Application for the discharge of a condition regarding planning application 3/2024/1022, allowed on appeal reference APP/T2350/W/25/3364654 on 25 September 2025.

Highcroft, Painter Wood, Whalley Old Road, Billington, Lancashire BB7 9JD.

**Planning Statement**

**Ref: JH.111225.A.2.B**

project Highcroft, Billington
 job no. 7676
 title false-colour material legend for north and west elevation
 scale 1:100 @ A3
 drawing no. al(05)0600

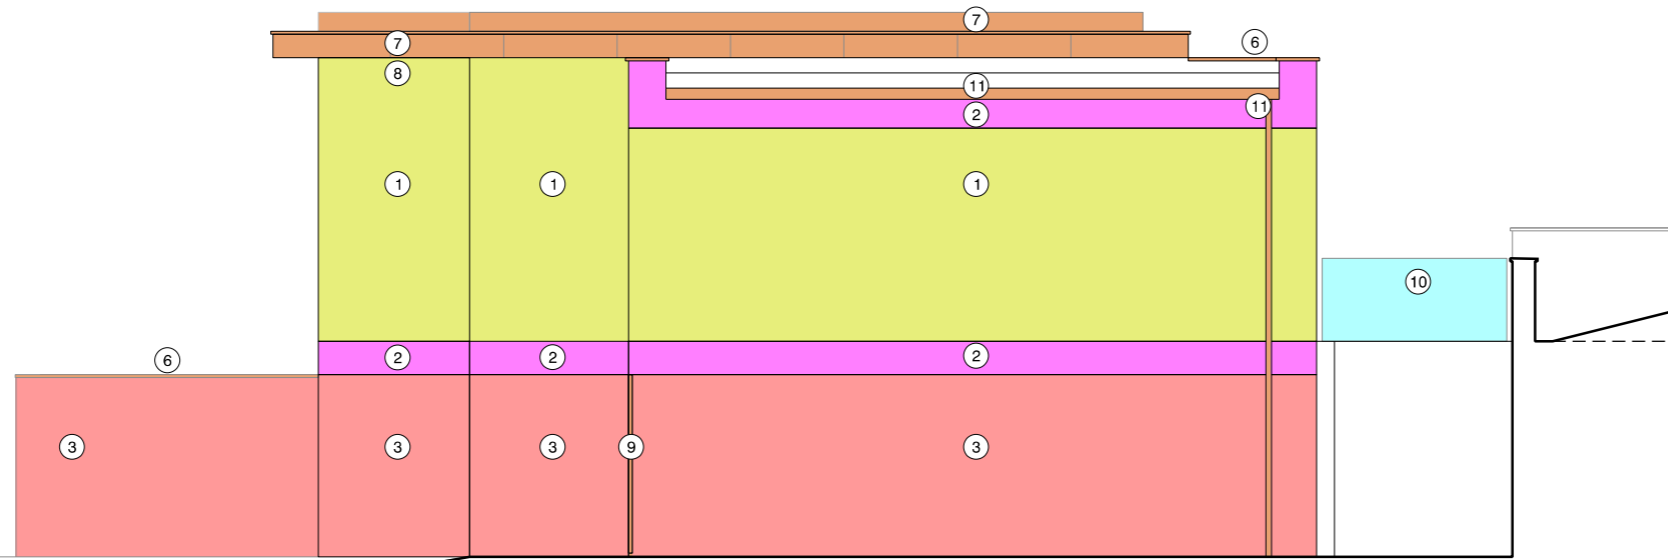
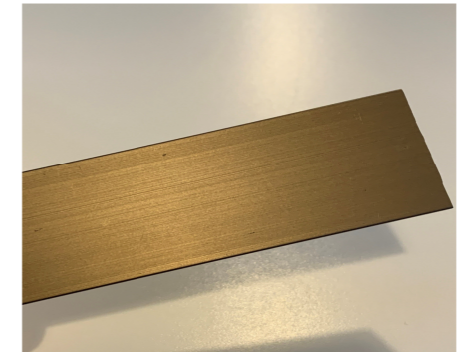
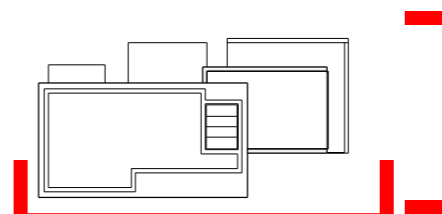
- *The sample of the bronze cladding is not sufficient and should be taken in daylight so that we can see the true colour*
- *Please clarify if the guttering will now not have the bronze cladding as per the original application?*
- *Please can you provide a photograph of a sample of the brick – there are concerns that the proposed brickwork colour is not appropriate in colour*
- *Please provide details of all external hard surfacing, not just the driveway e.g. rear patio areas, walkways, kitchen garden, fixings for the glazed balustrade and glazing opacity*
- *Please provide photographs of the natural stone flags*
- *Drawing ref: al(05)0600 does not reference zinc referred to in your statement, please clarify’*

- My apologies. My reference to zinc should state bronze

- Following shows the colour of the bronze cladding RAL 1036

- The guttering would be in the above bronze material, as part of the original application
- The proposed brick would be as shown on the previously submitted 'Samples of proposed external materials'. It would be the only brickwork on the building and so would not have to match any other brickwork on it. It would be a sympathetic colour and type to that approved by the for the houses on the opposite side of the road: as well as the hue of the adjoining terraced houses: -

WATER RECORD

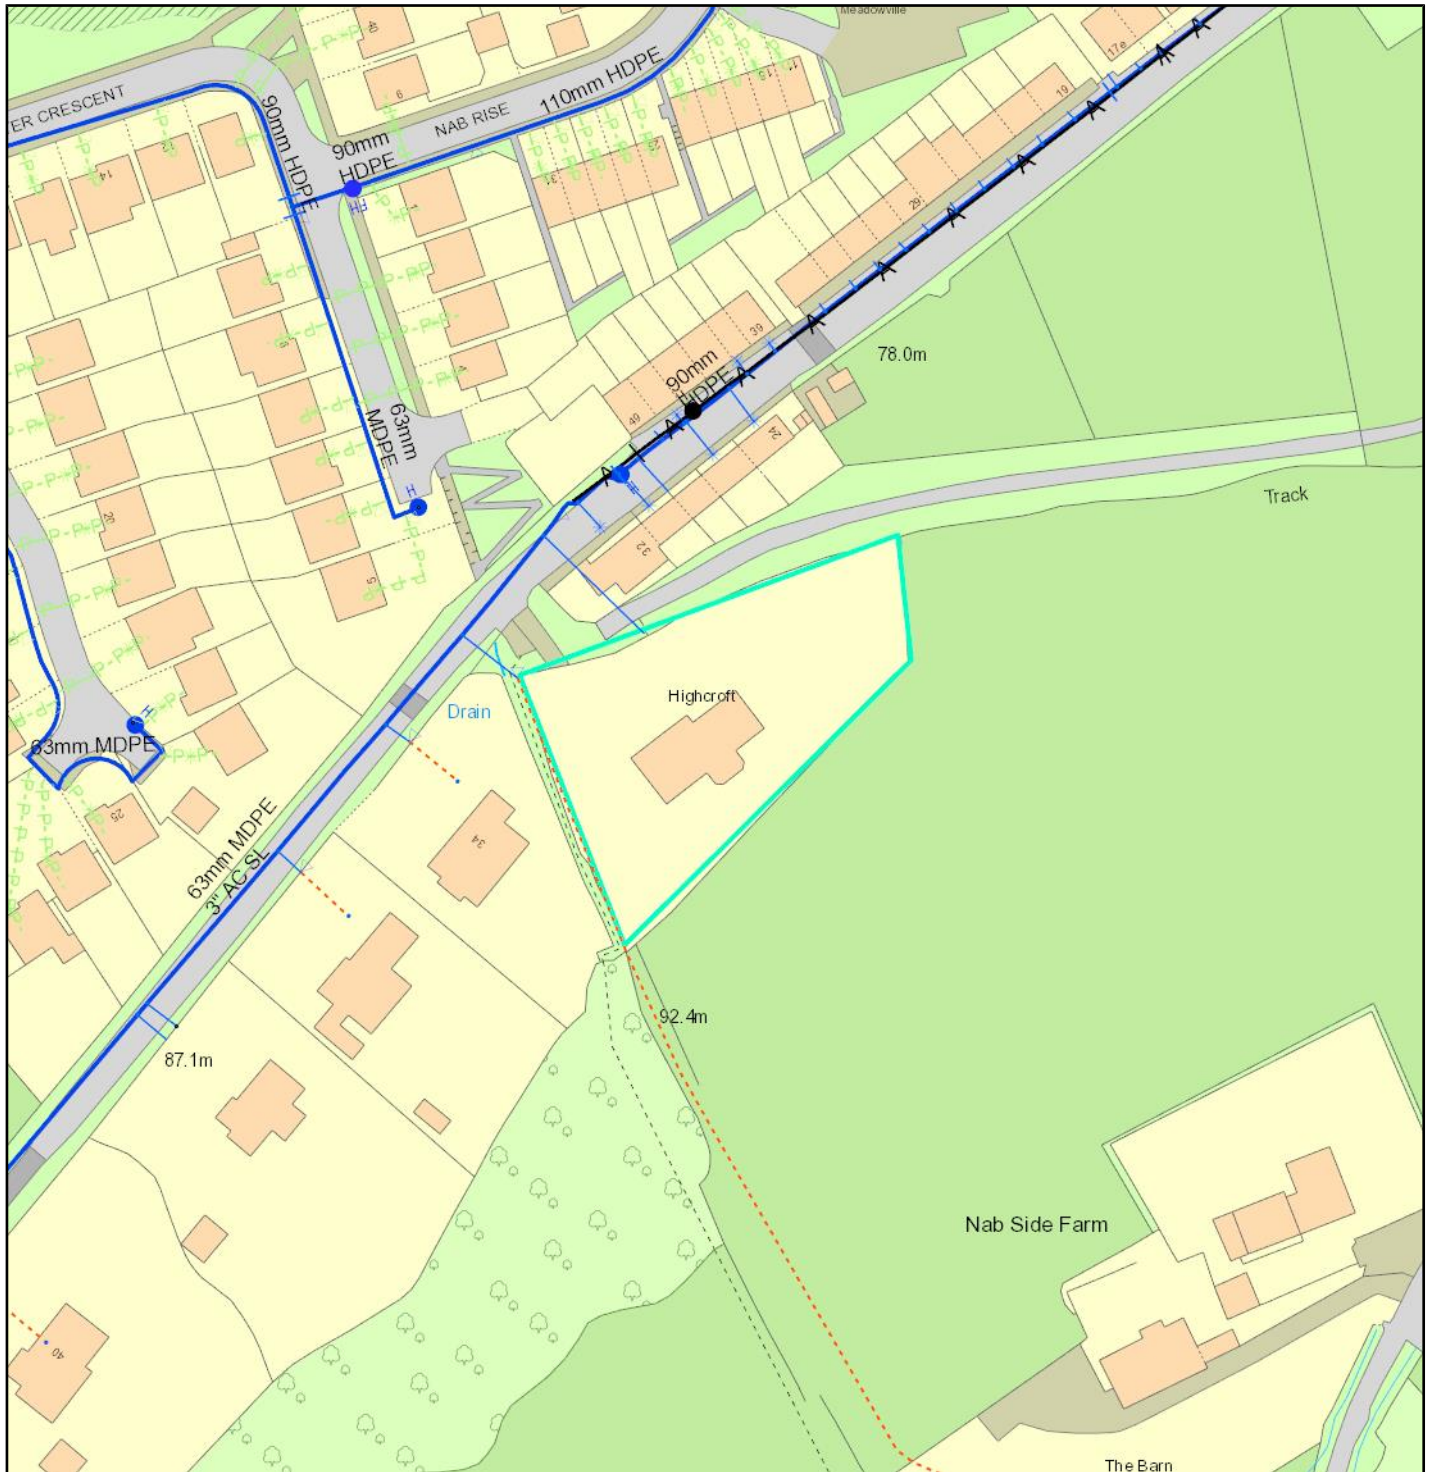
*Drainage – The proposed scheme involves excavation works, new hardstanding and walls. At the very least, we require evidence to demonstrate that the proposal would result in no greater impact to flood risk than the existing. It is not considered the information submitted demonstrates this.*

The above submission relating to the garden area supplements our earlier submission indicating the continued drainage of the house to the United Utilities (UU) drain in the highway, as shown on the submitted UU plan.
